BUILDING CODE OF AUSTRALIA REPORT

Proposed Residential Development Site 3 – Sydney Olympic Park

Dated: 9 April 2011

Prepared for: Site 3 Development Company Pty Limited

Site 3
Sydney Olympic Park
Plan
Basement 002

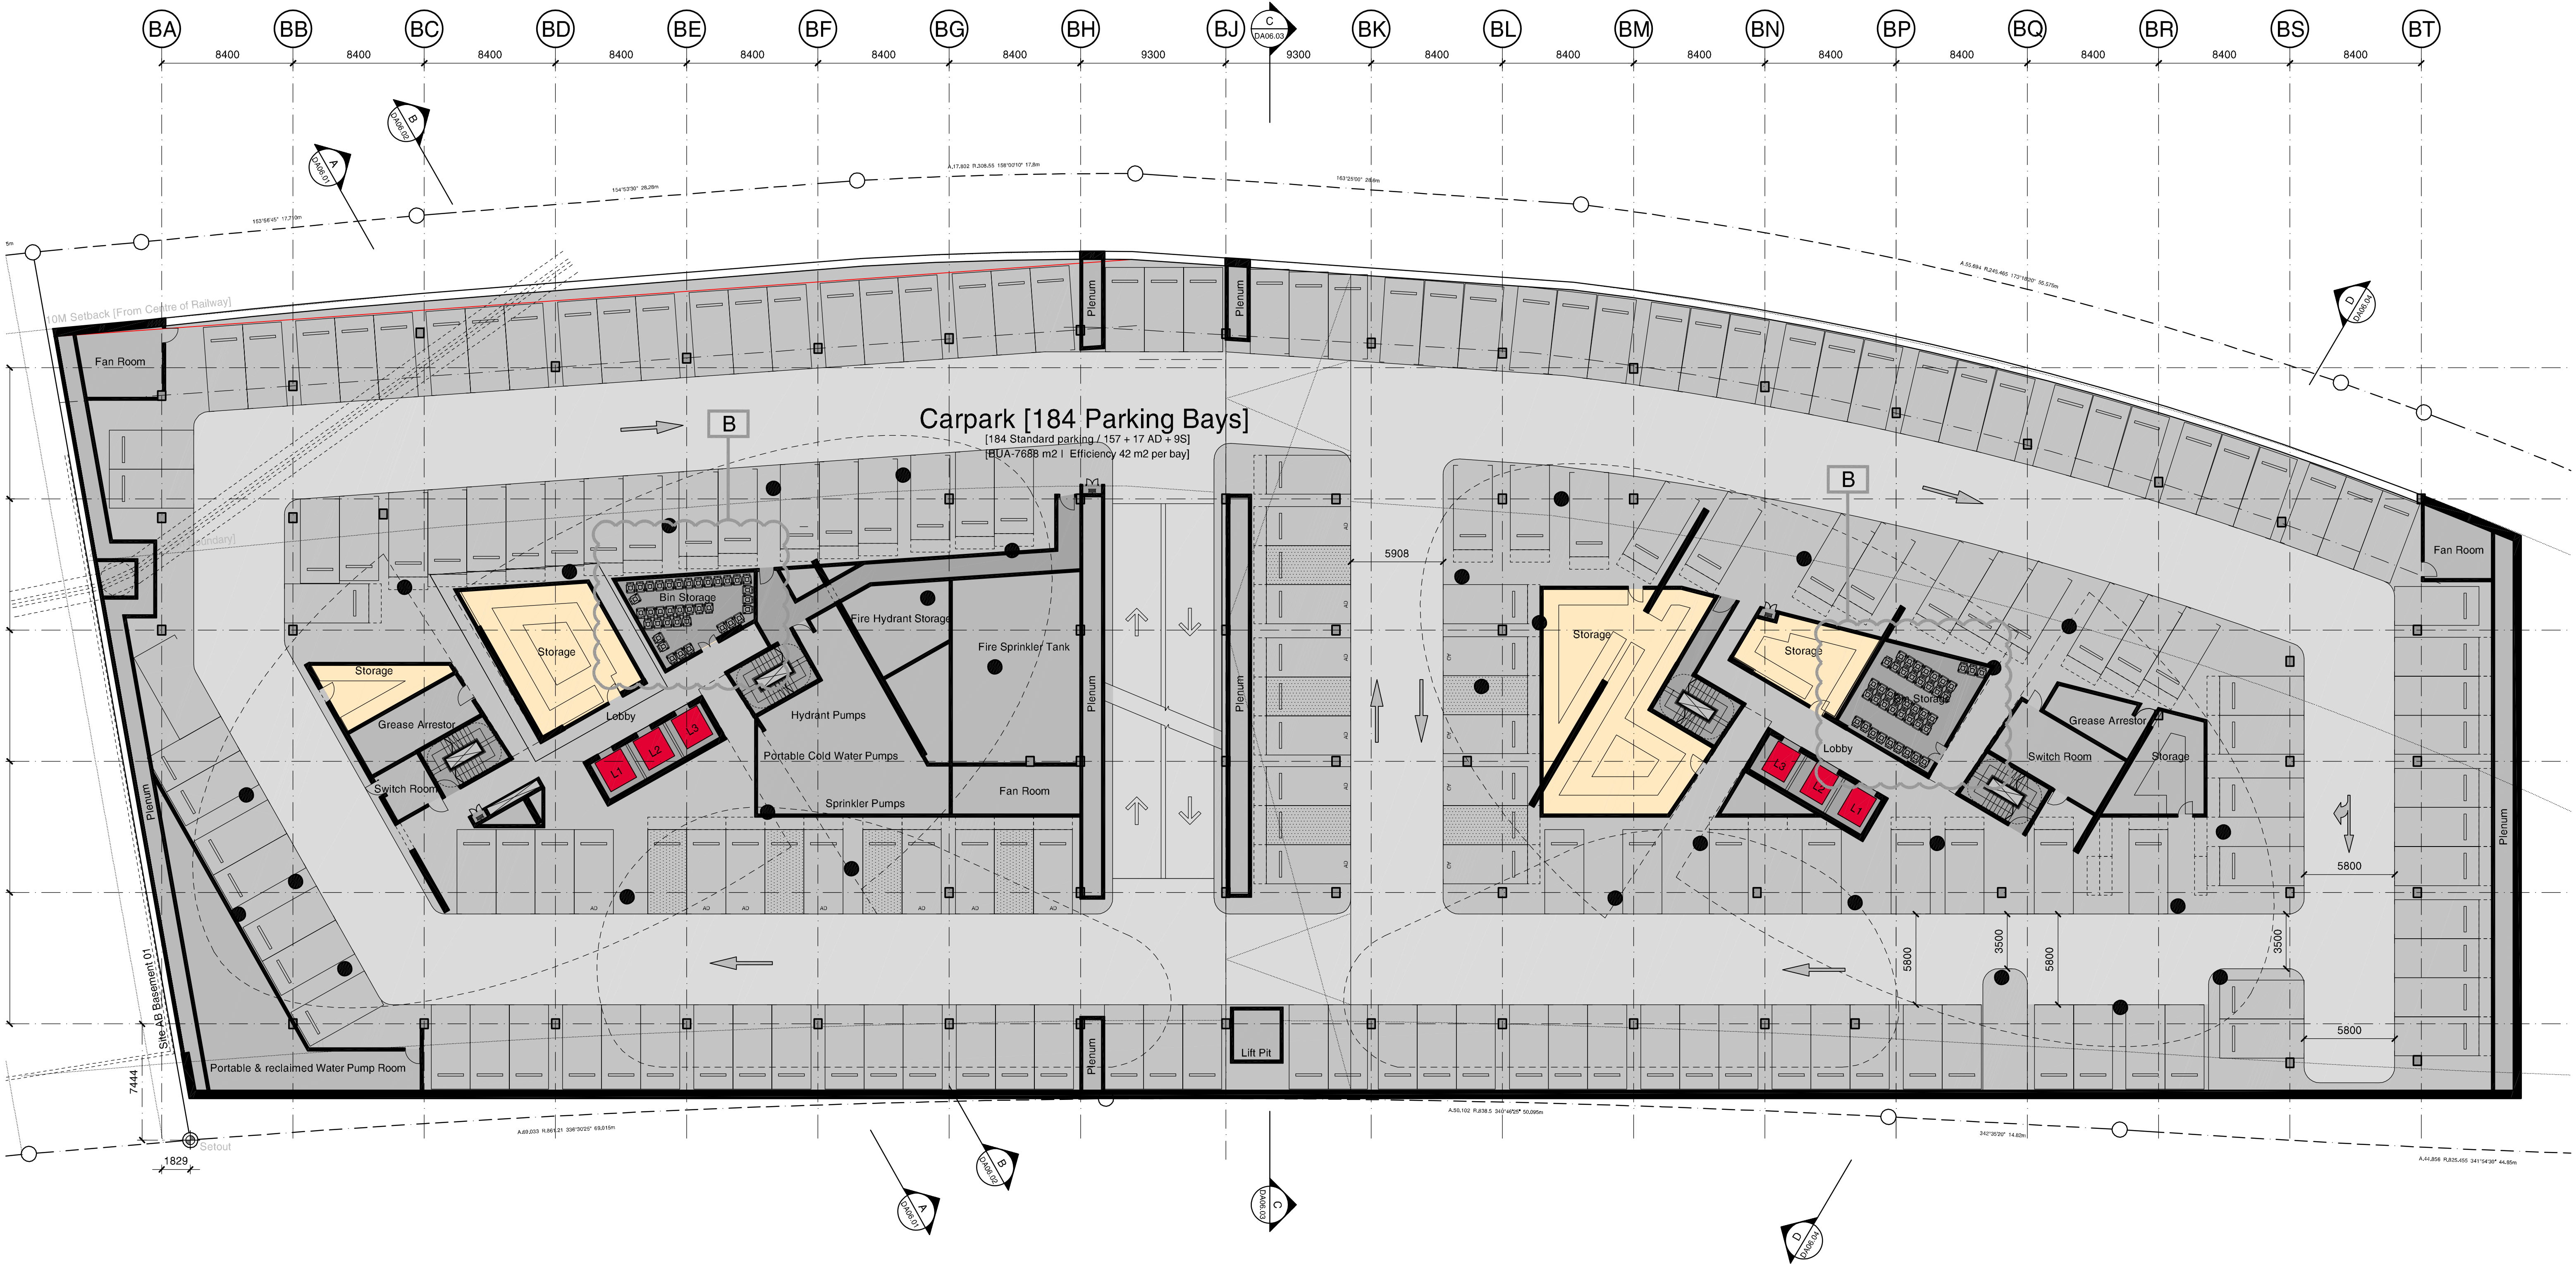
- Travel distance to required exits will exceed 20.0m to point of choice and 40.0m to required exits;

Refer to preliminary advice from Defire in respect to maximum travel distances that can be addressed by an alternative solution to satisfy the performance requirements of the BCA.
